Date: 29 August 2023
Our ref: 64182/01/CD/CSm/26935883v1
Your ref: 2022/62/93154/W

Land at Penistone Road, Fenay Bridge (Application Reference: 2022/62/93154/W): Updated Application Drawings

Updated Application Drawings

RIPPONDEN

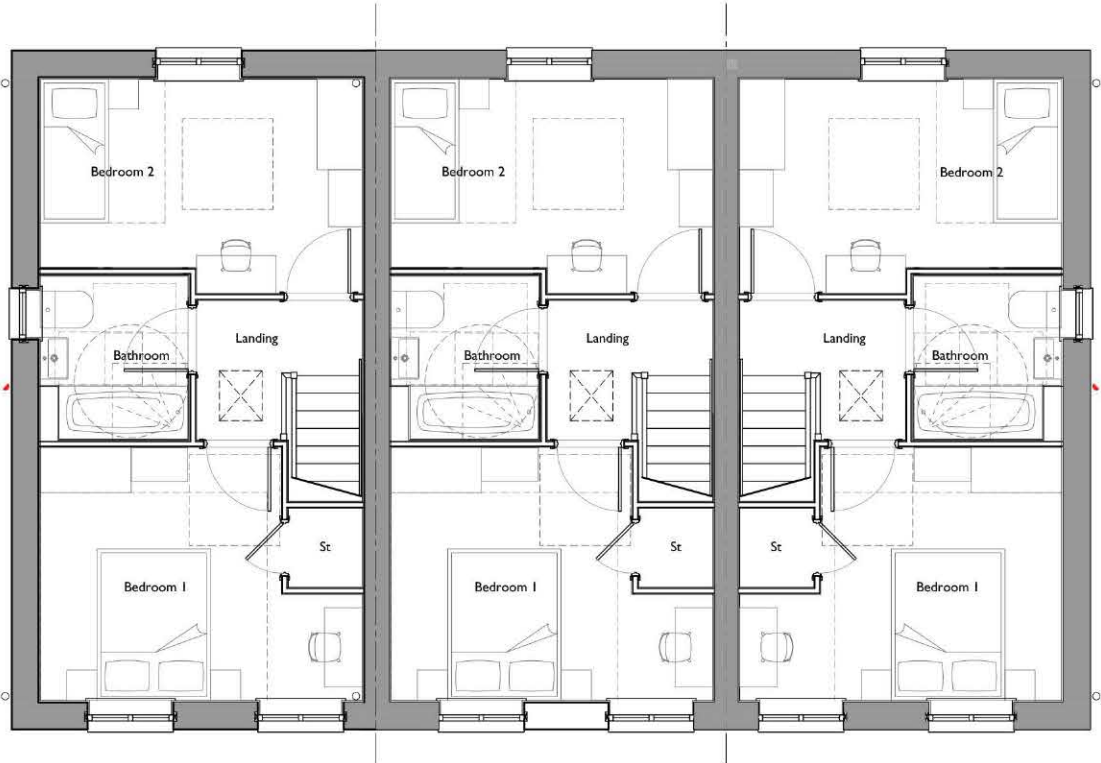
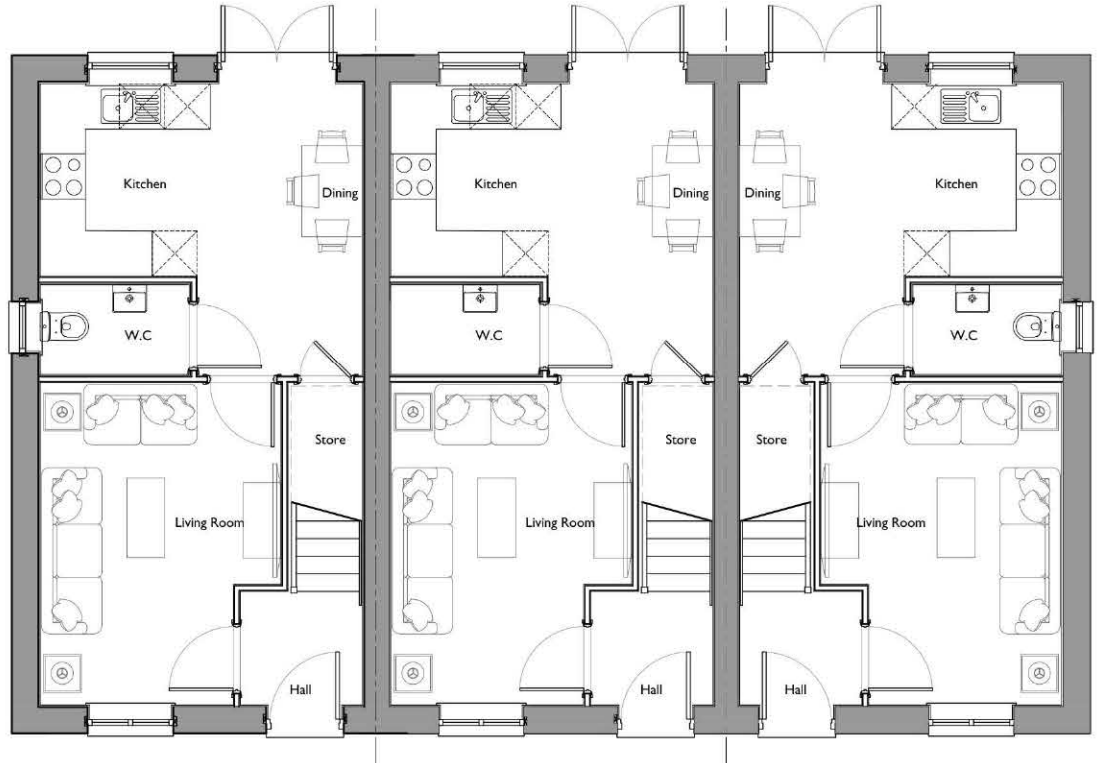
- Linked with the point above, the original Elm and T3 house types are proposed to be replaced with the Dalton and Ripponden house types as these new house types include two first floor windows on their front elevation.

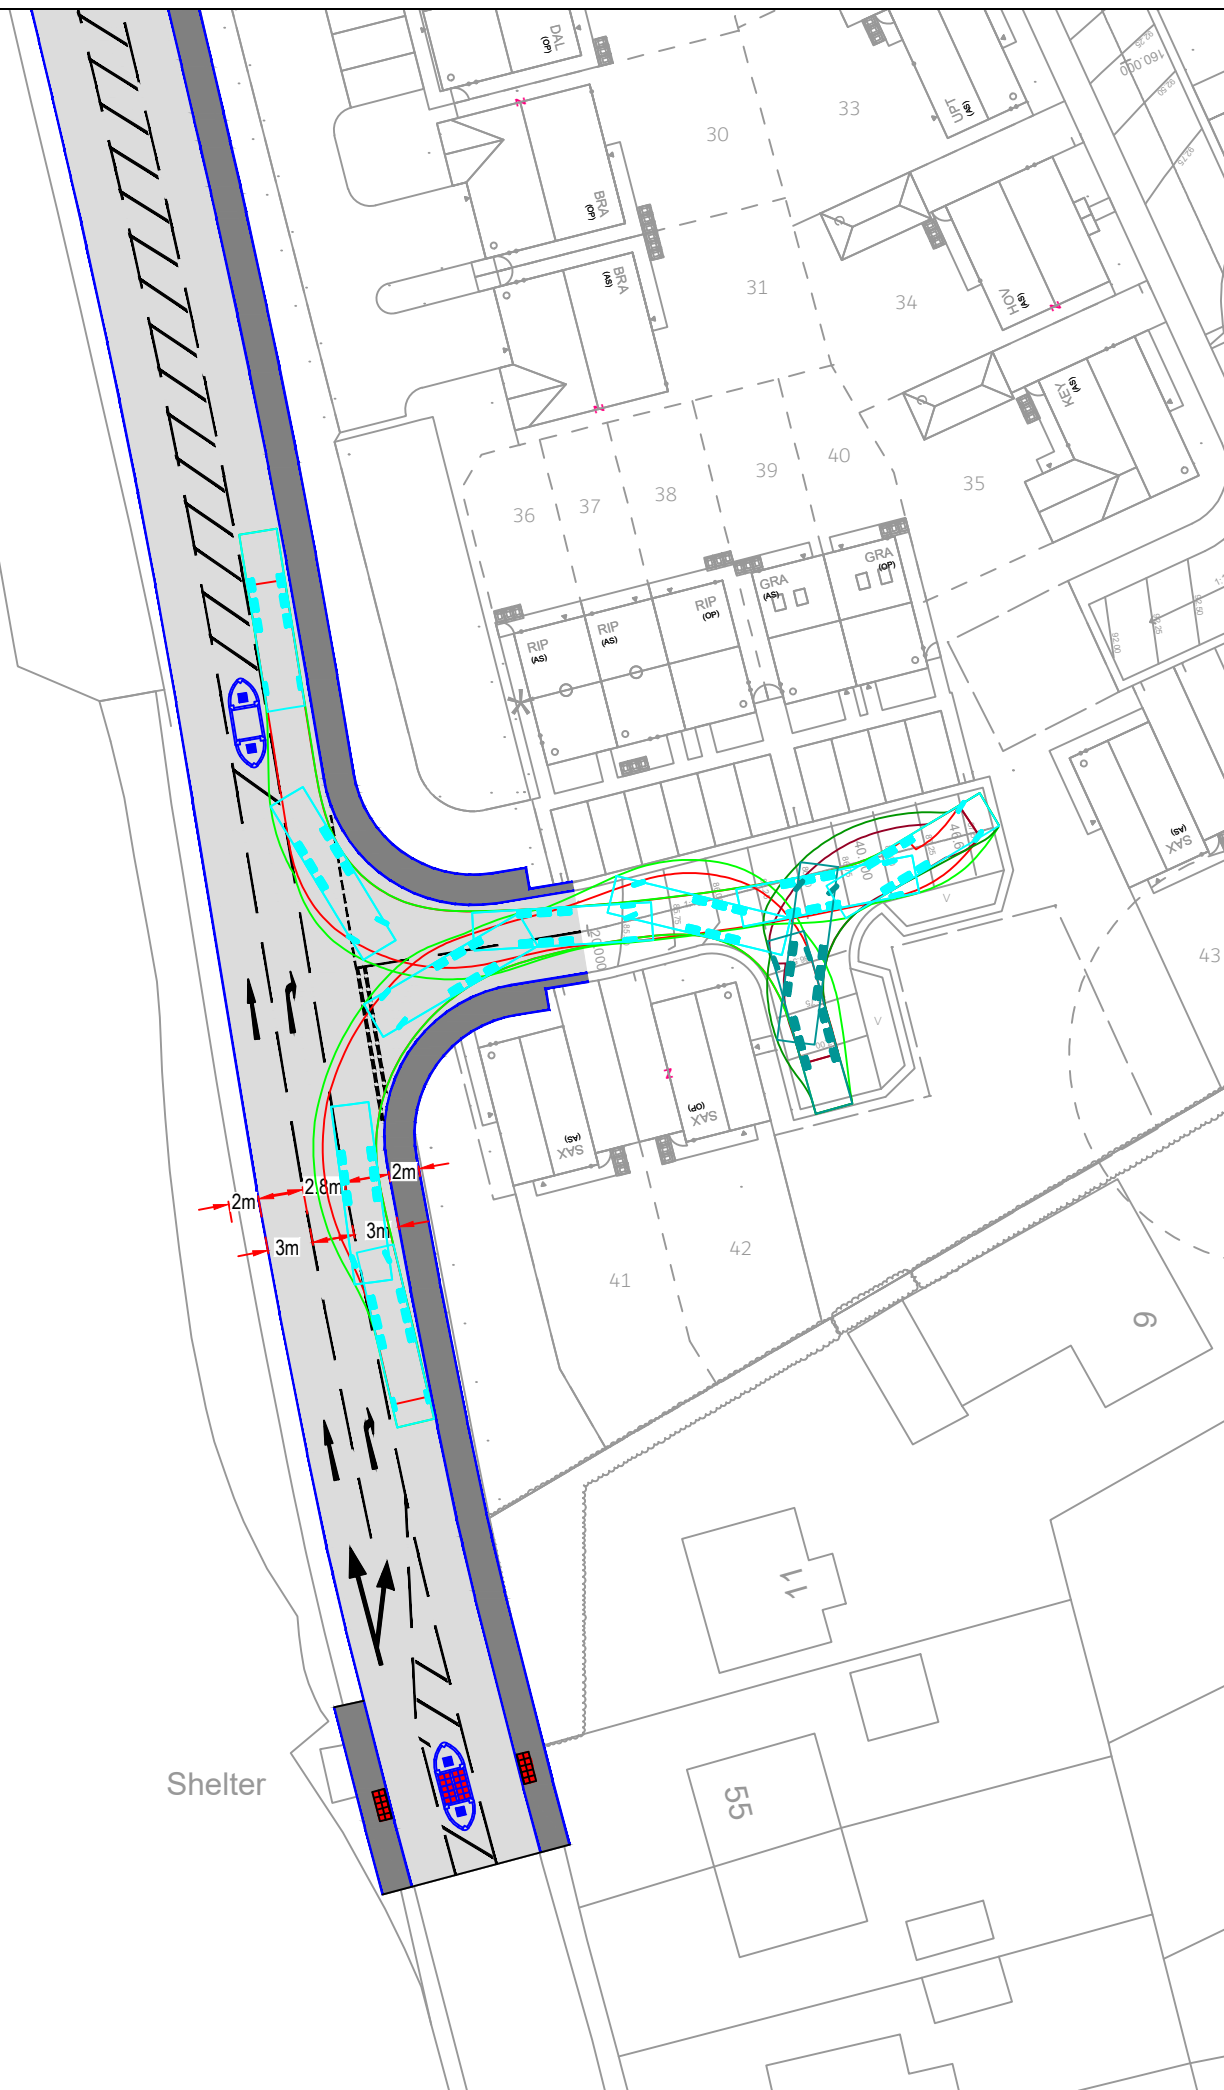
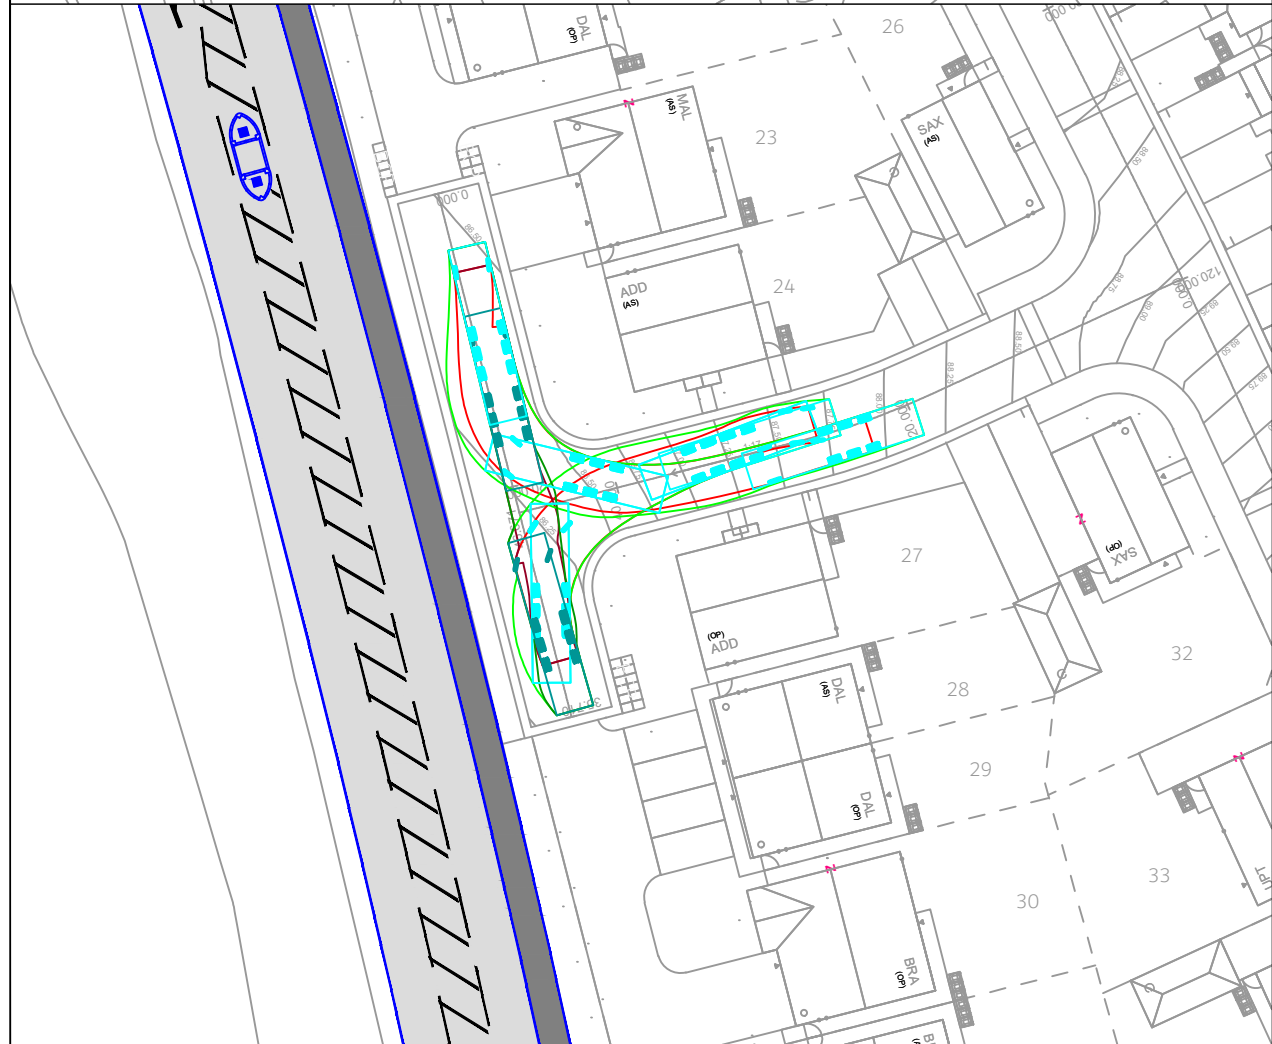
- The two proposed visitor parking spaces serving plots 36-42 have been repositioned to ensure that the vehicle turning head remains technically acceptable whilst ensuring the amount of fenced off 'natural / semi-natural open space' is protected. In terms of the turning head remaining technically acceptable, this is demonstrated by the enclosed technical swept path analysis drawing (ref. AMA/21312/ATRo12 Rev P01).
